**City of Sydney**

11 June 2009

**Proposed Sydney CityGrid Project – (Application: 08\_0075)**

Figure 6-4 Indicative layout of Riley Street construction compound

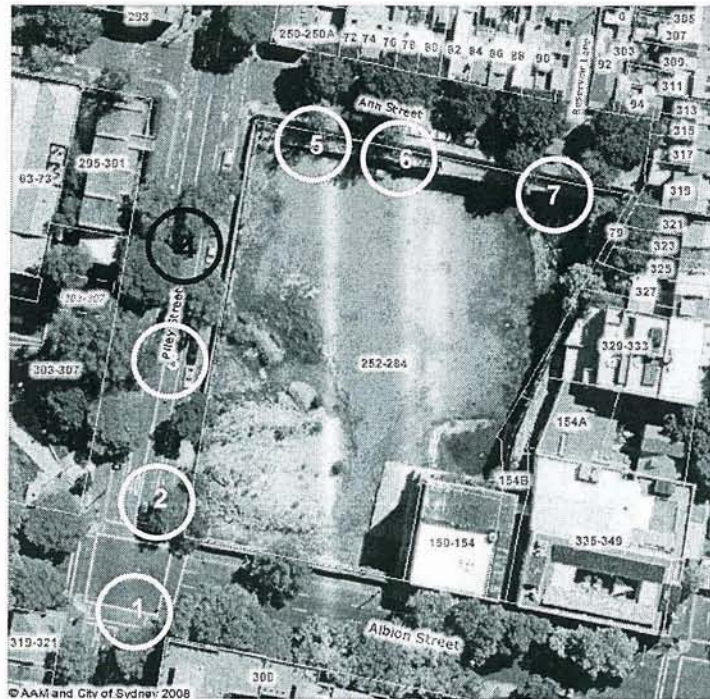
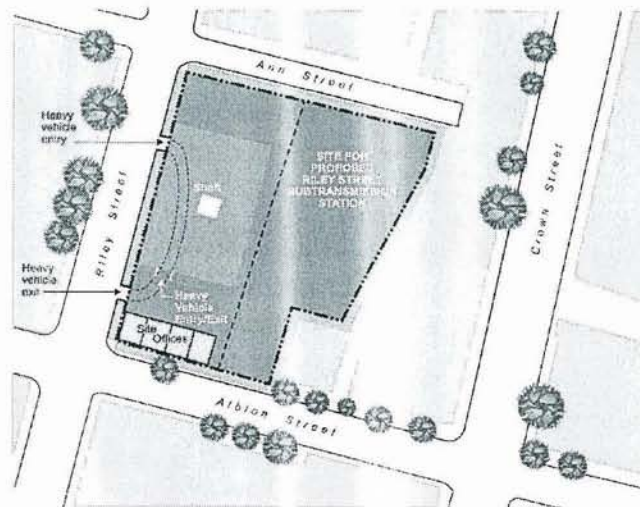
The tree on the eastern side of Riley St, 1<sup>st</sup> tree south of Ann St, may be removed to facilitate the proposed vehicle entry point. All other council street trees along the site boundary, which are of medium-high retention value, are to be retained.
